West Yorkshire Police
Kirklees District

Designing Out Crime Officer

To: Ellie Thornhill Kirklees Council Planning Services	Ref: 2023/93350 Date: 6th December 2023
--	---

Site Location: Former Deighton Centre, Deighton Road, Deighton, Huddersfield, HD2 1JP
Application: Development of new Social Emotional and Mental Health School

BOUNDARY TREATMENTS

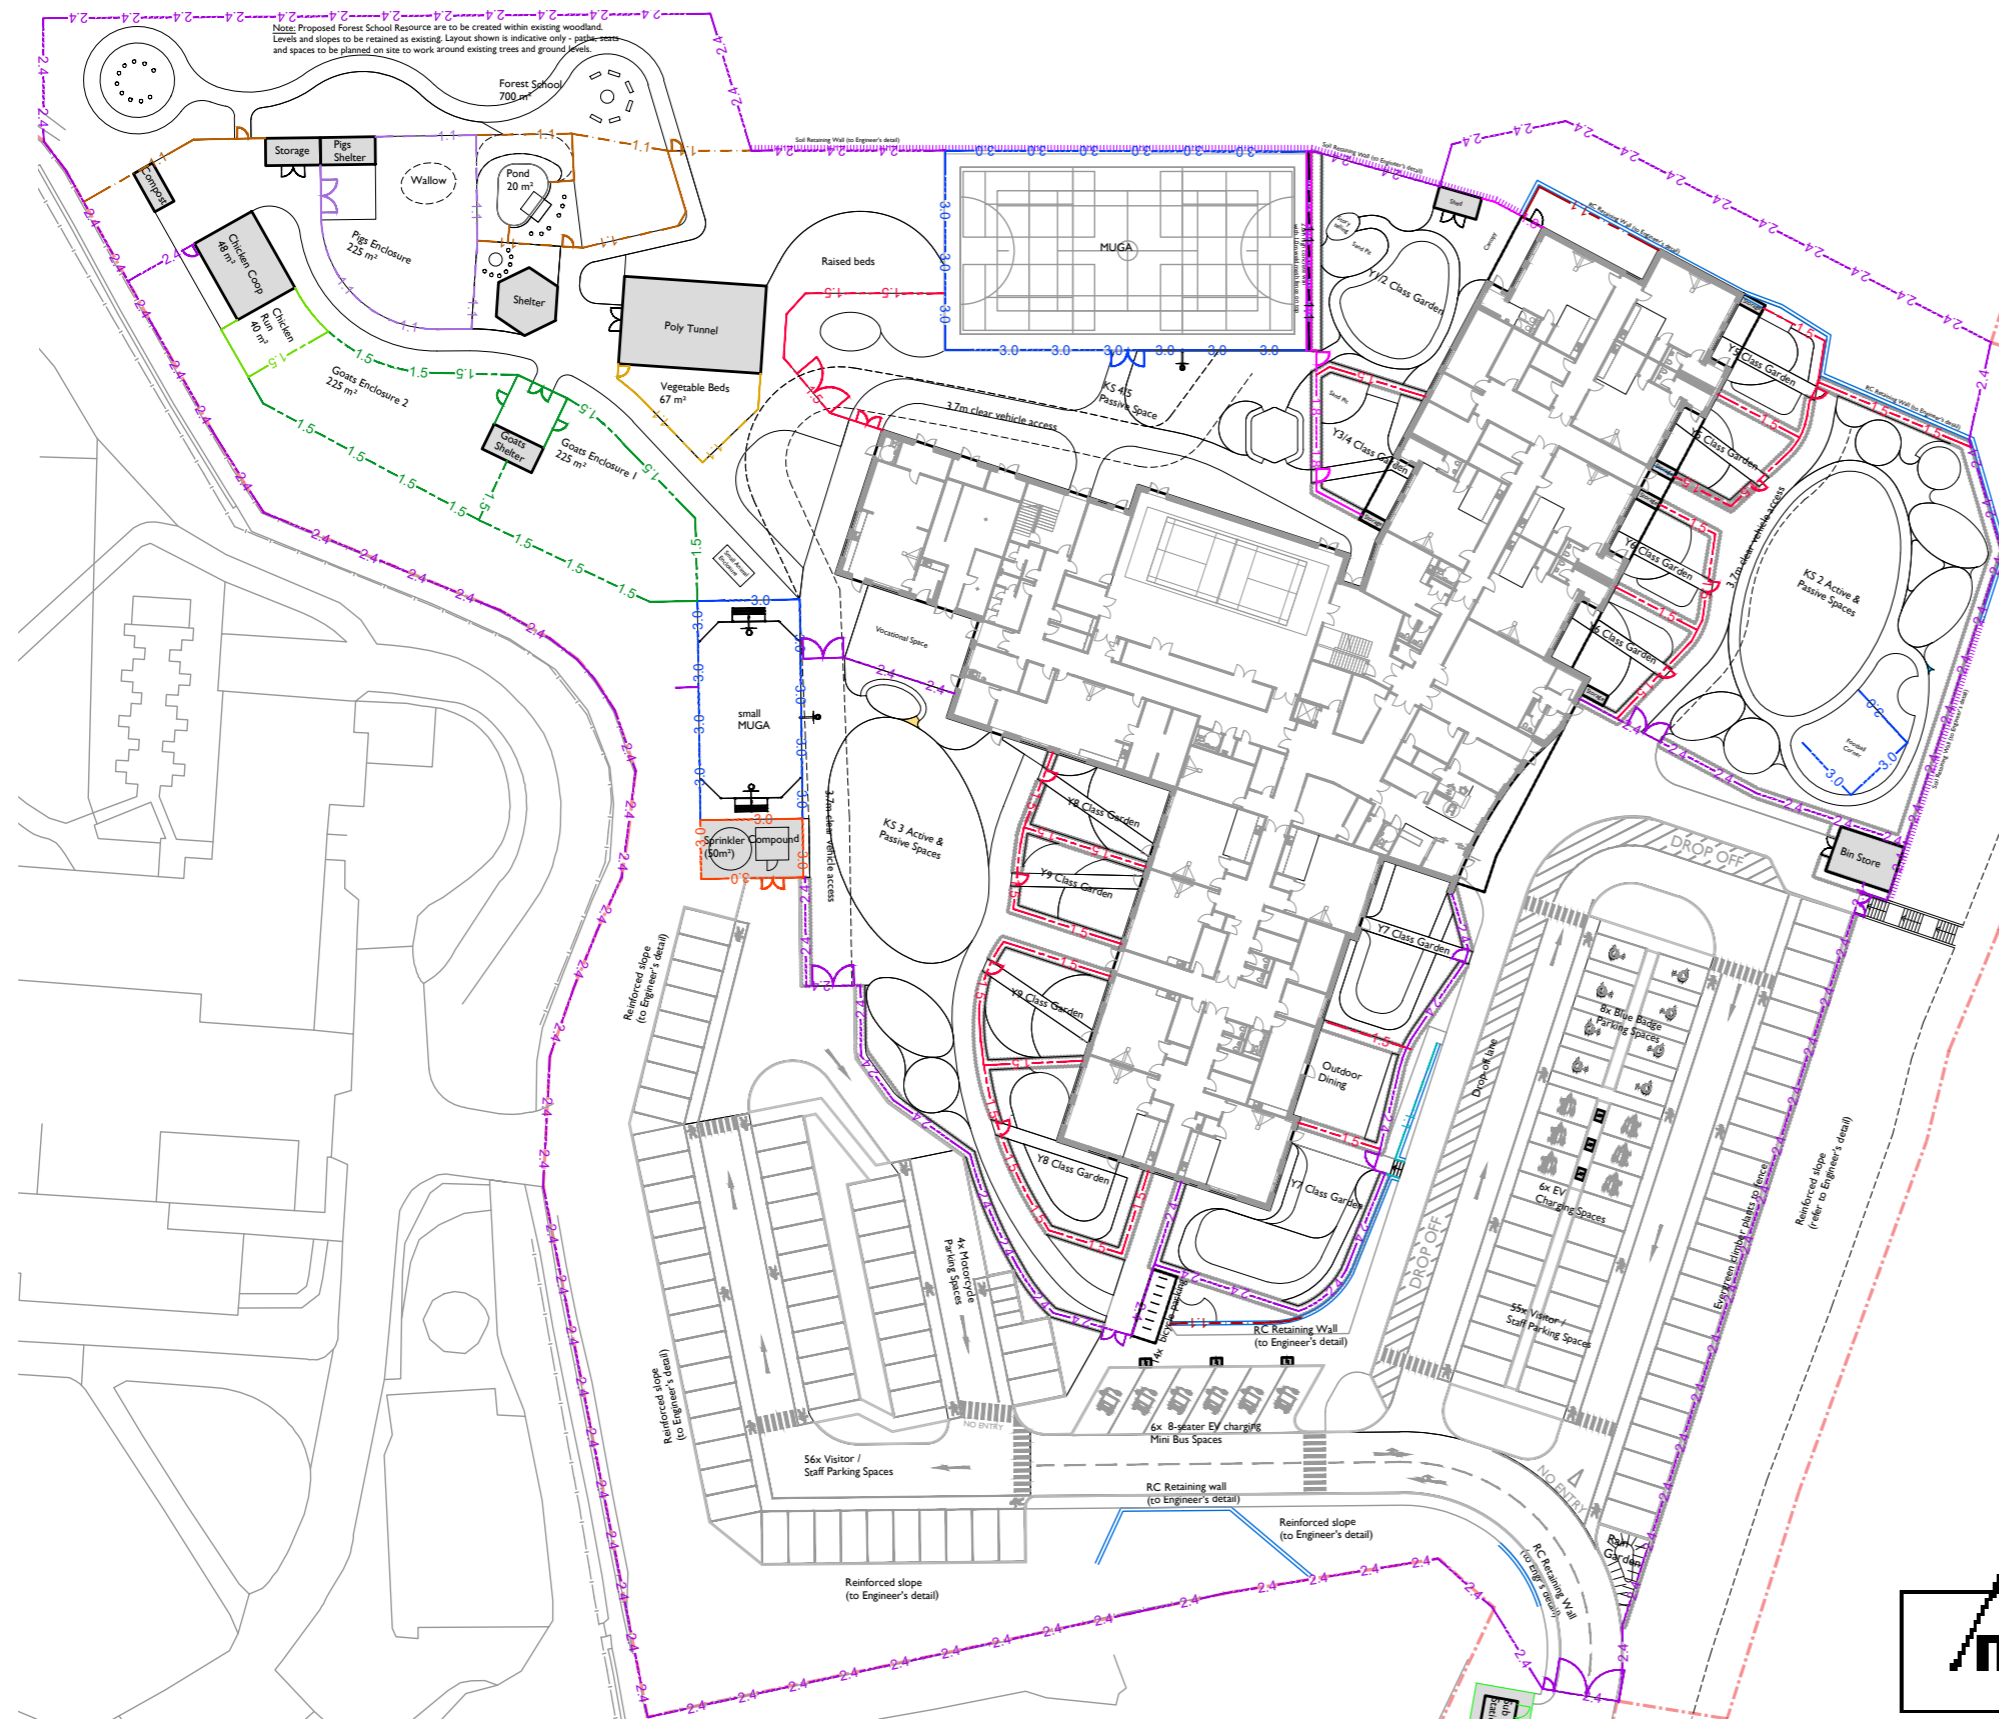
Security fencing must be installed around the site perimeter. Materials may include welded mesh and expanded metal available in numerous coloured coatings, which are sometimes used in conjunction with timber. Railings of various designs can be used to good effect and all fencing types 2.4m above ground level, can be fitted with hostile toppings to deter climbing. I would recommend the boundary treatments for the site be robust to a height of 2400mm with signage stating the use of hostile or defensive toppings to be placed around the exterior of the perimeter fencing at regular intervals.

Access must be restricted from public land by installing a lockable gate of the same material and same height as the fencing.

It is advised that the boundary fencing is defended with defensive planting to the outside of the fence.

It is essential that all fencing and boundary treatments be designed so that the external face is flat with no footholds for climbing. This applies to any gates used on the site as well.

The design, height, and construction of any gates within a perimeter fencing system should match that of the adjoining fence and not compromise the overall security of the boundary.

Access must be restricted to the perimeter defensible space from public land by installing a lockable gate of the same material and same height as the fencing. It is advised that the gate construction is such that no footholds or cross members are accessible from the outside of the gate, especially around the locking mechanism to prevent climbing.
